CITY OF ALBUQUERQUE

July 16, 2013

Re: Bob's Burgers, West Central/46th Street, Grading and Drainage Plan
Engineer's Stamp dated 06-21-2013 (K-12/D032)

GRADING PLAN

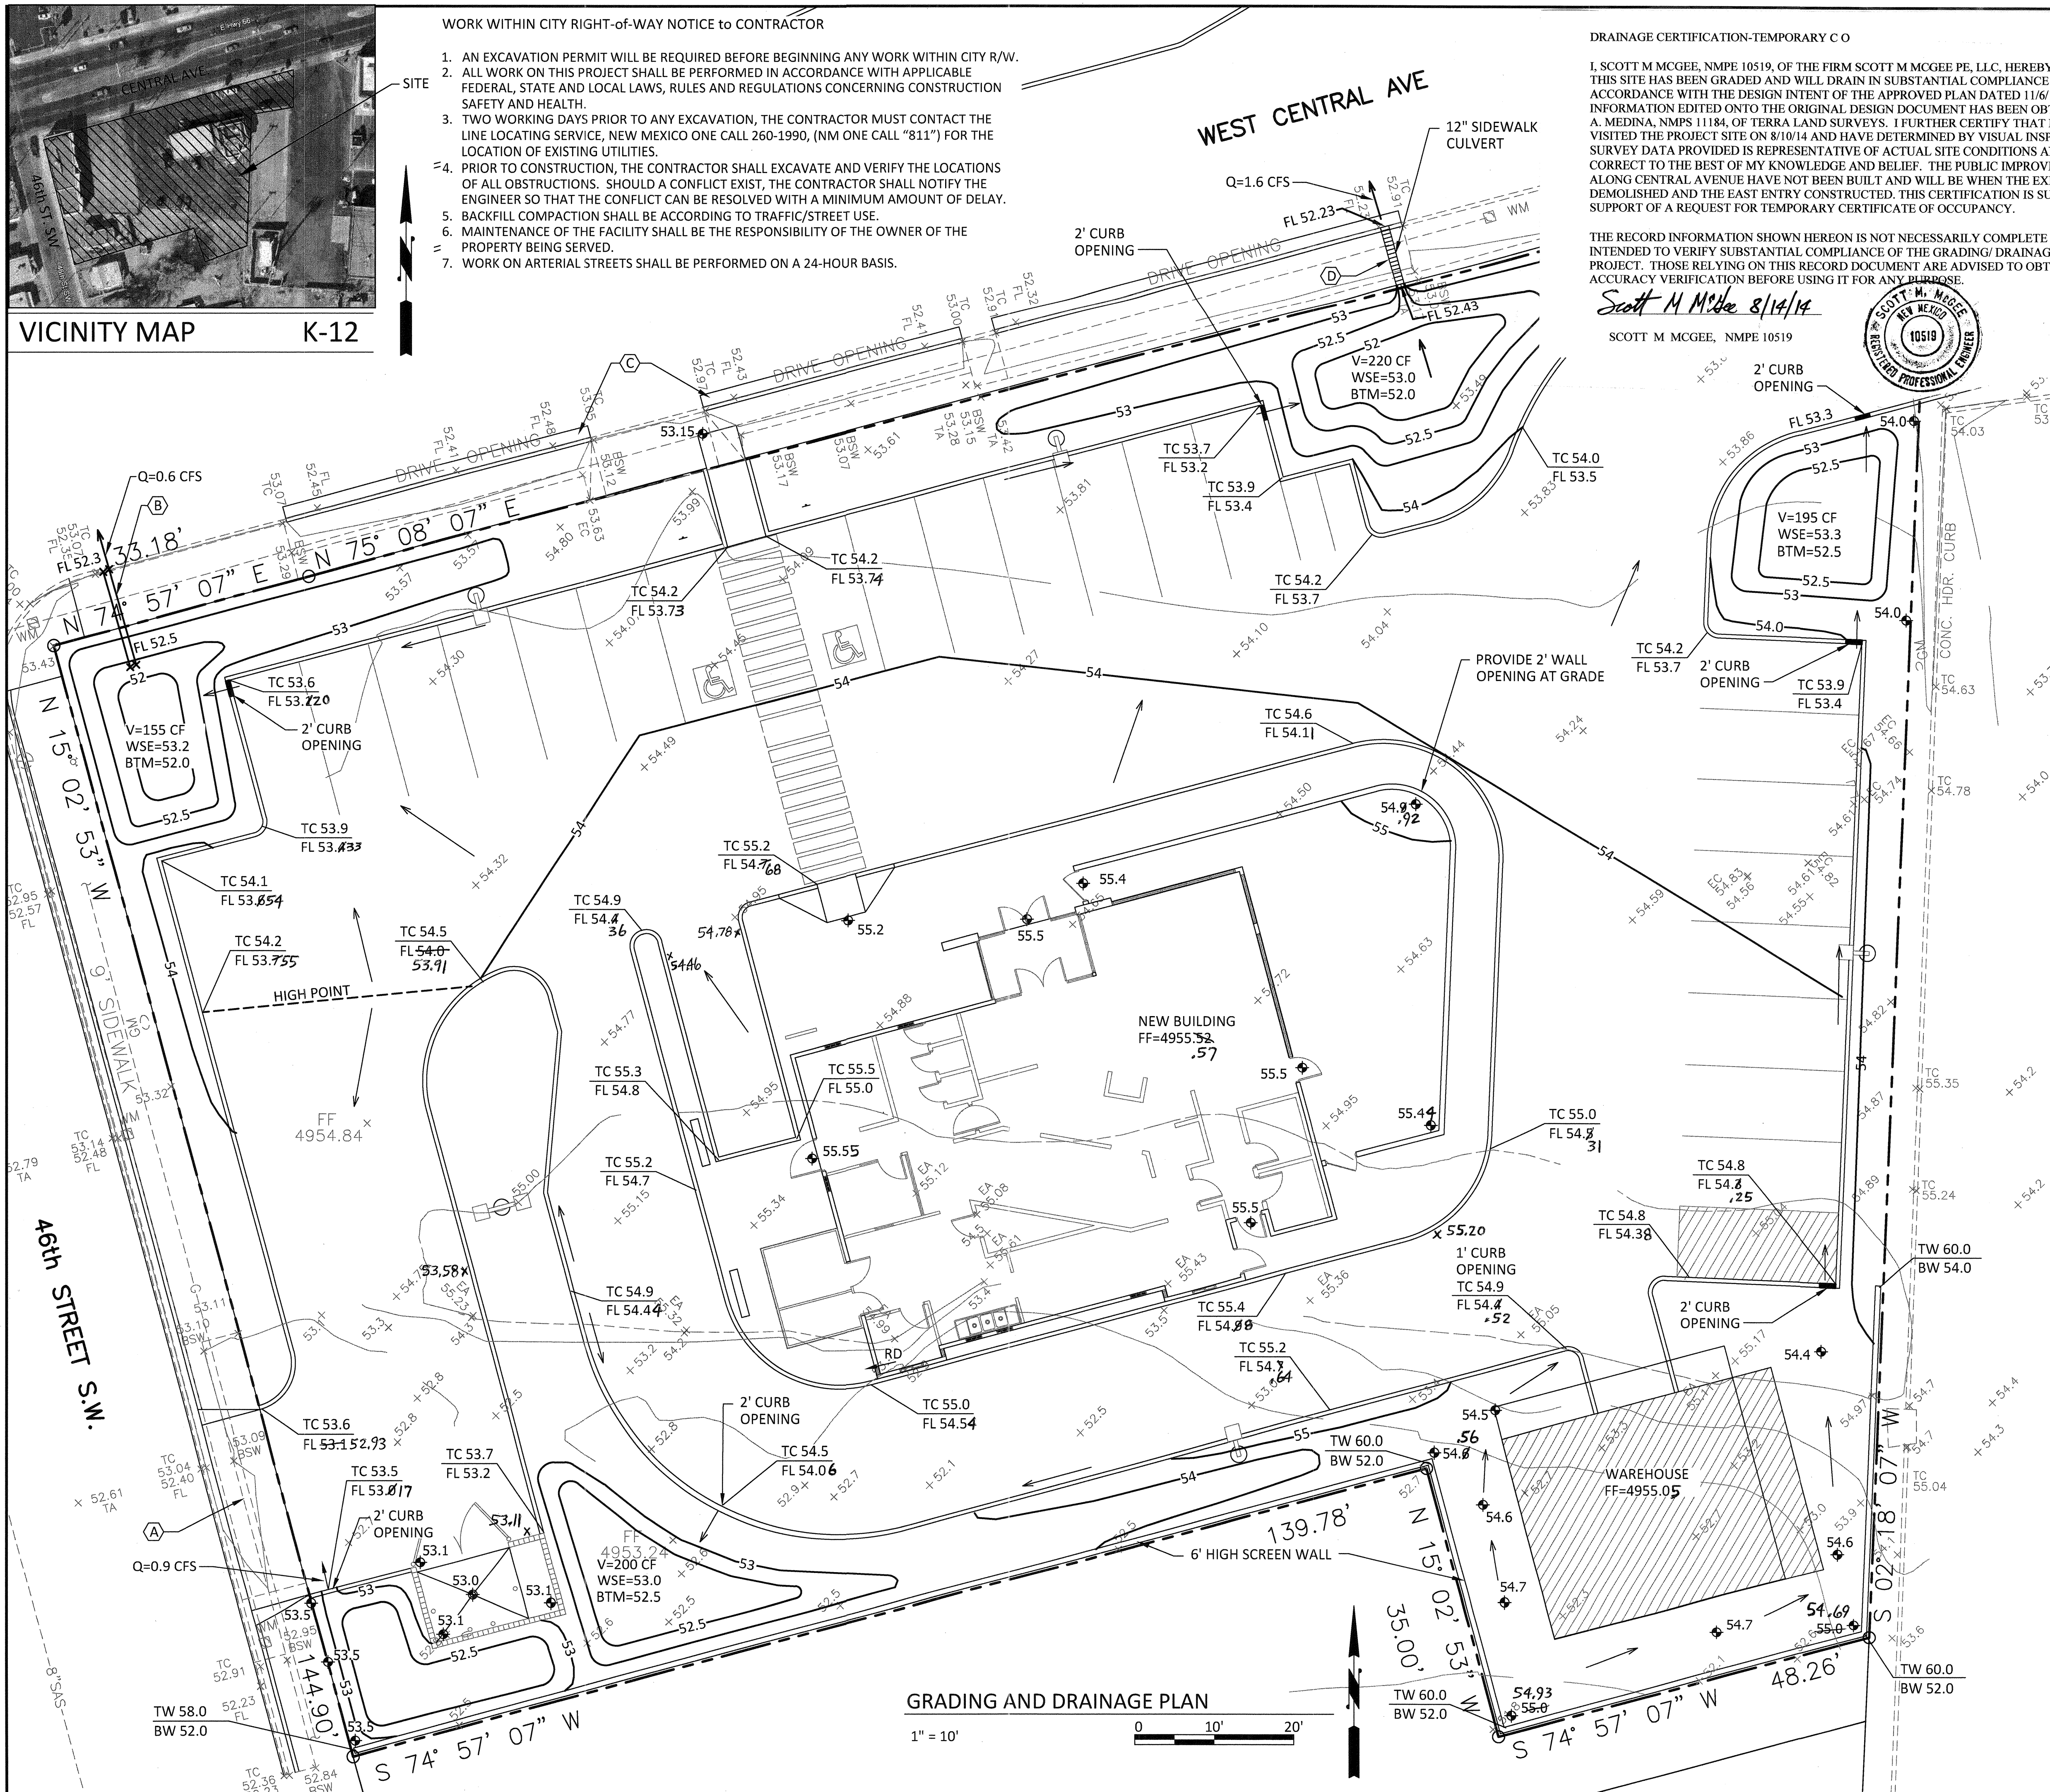
- Please clarify the property line boundaries.
- Provide evidence of a drainage easement with Tract A for the proposed 2' curb opening on the eastern drive.
- An additional access easement will need to be provided for the eastern driveway.

- Both proposed curb penetrations need to reference City Standard Drawing #2235. The SO-19 standard notes need to be added to the grading plan.
- Provide additional spot elevations at the sidewalk connection for the ADA path.
- Provide pond calculations for each of the proposed water harvesting ponds.
- Provide top-of-pond and bottom-of-pond elevations for the ponds along with flow calculations and capacity for the two pipe penetrations along Central Ave. Runoff will not be allowed to drain over the sidewalk.
- Are the sidewalks on the plan proposed or existing?
- The trash enclosure will need to show a drain connection to the sanitary sewer system. Provide additional spot elevations at the corners of the enclosure.
